Planning Application Ref: **AW/112/20/T**

Location: **Aldwick Farm, Aldwick Road, Bognor Regis, PO21 3RN**

Description of works: **Crown lift 1No. lime tree (T1) to 5m above ground level and reduce lateral growth back by 2m up to a height of 7m**

TREE LOCATION PLAN.

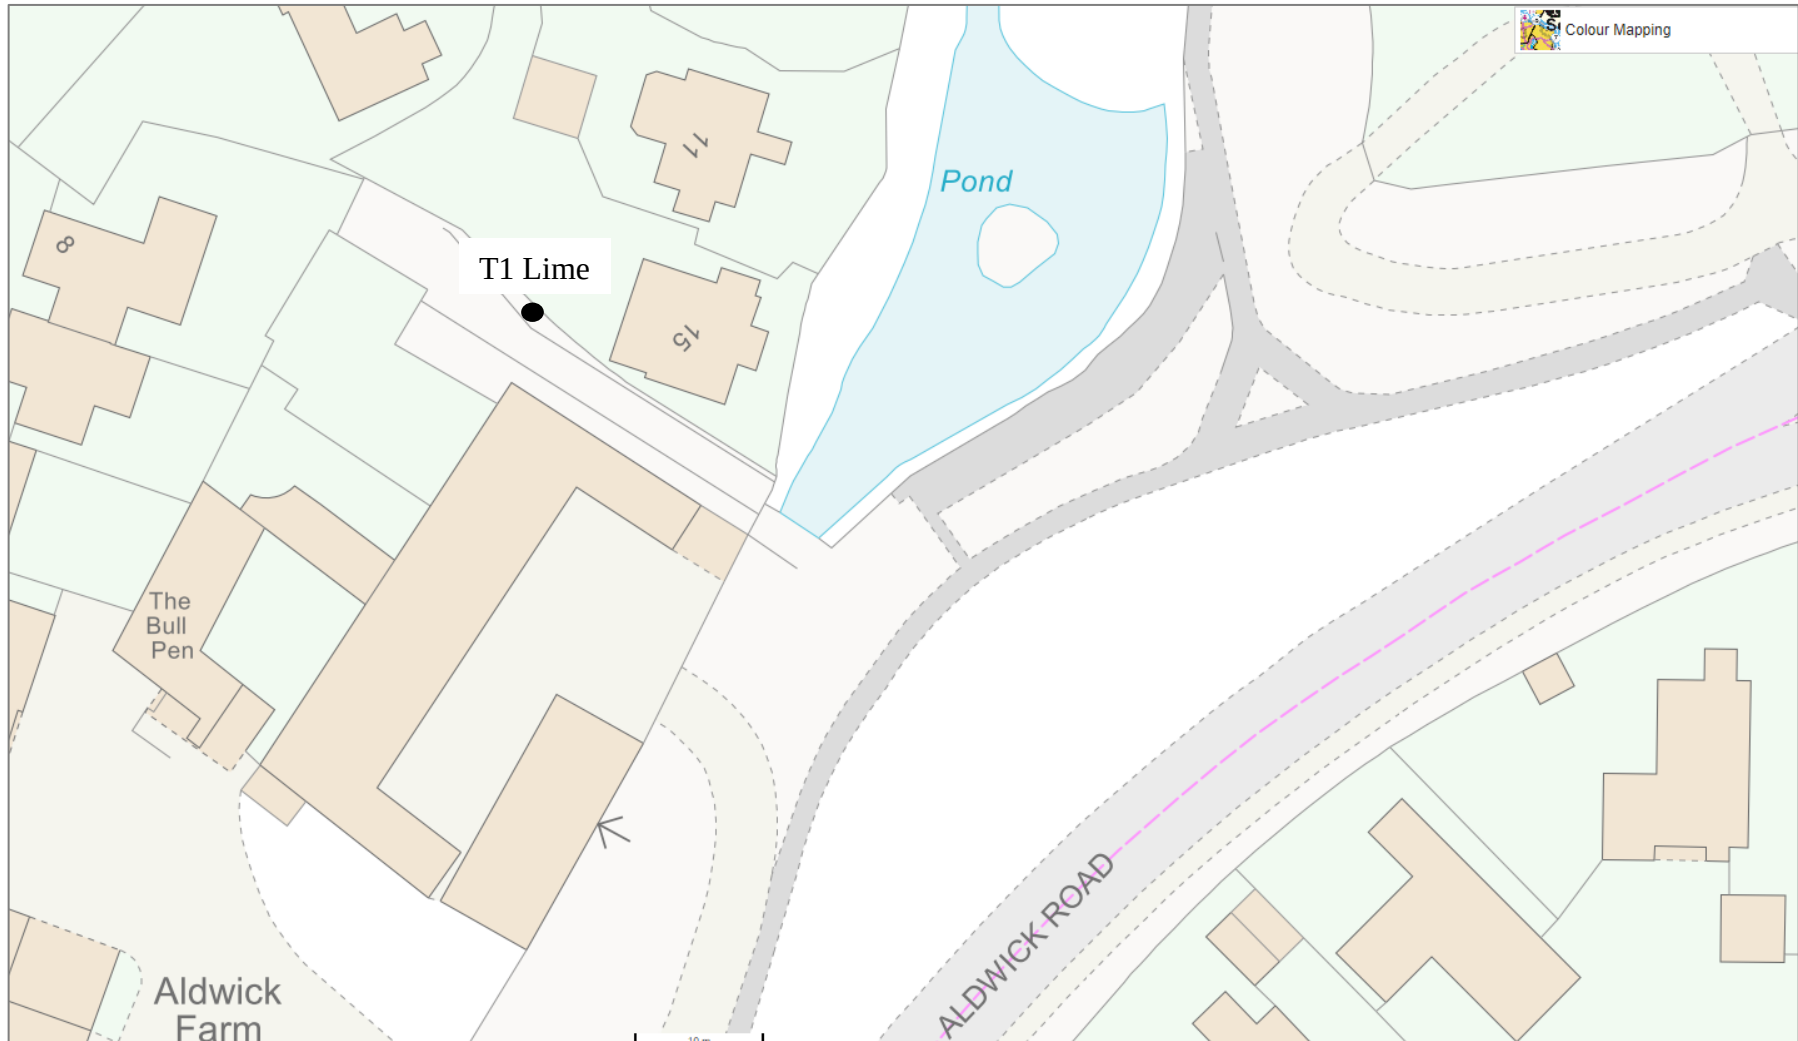
Lime / *Tilia* sp. Height: 15-20m Spread: 0-5m Age class: Mature

- This tree was assessed from several aspects at a distance sufficient only to determine visual amenity value and general physiological condition.
- Outwardly it appears to be in a fine state, of narrow form and with an attractive crown profile. It is somewhat confined by surrounding development (mostly residential) so that it has considerable presence over the same but limited visibility from publicly accessible land
- The applicant has employed Chichester Tree Services as agent, who have provided an annotated photograph of the above tree that both illustrates and describes a detailed work proposal, which meets the requirements of British Standard 3998:2010 – Tree Work.

- The work proposed is justified on arboricultural grounds as it seeks to strike a balance between the tree's influence and potential impact on surrounding residential property and the need to retain trees with dignity by having respect for natural tree form.
- If the work is undertaken at the right time and to a high standard it will incur no loss of public amenity.

- I recommend **CONSENT** for this application, subject to the following condition:

- Part a) Where whole branches are to be removed and final cuts made close to the trunk or branch union they are to be made as shown in Figure 2 of BS3998:2010
- Part b) Where branches are to be shortened back the final cuts are to be made at the correct angle shown in BS3998:2010 and adjacent to a live bud or lateral.
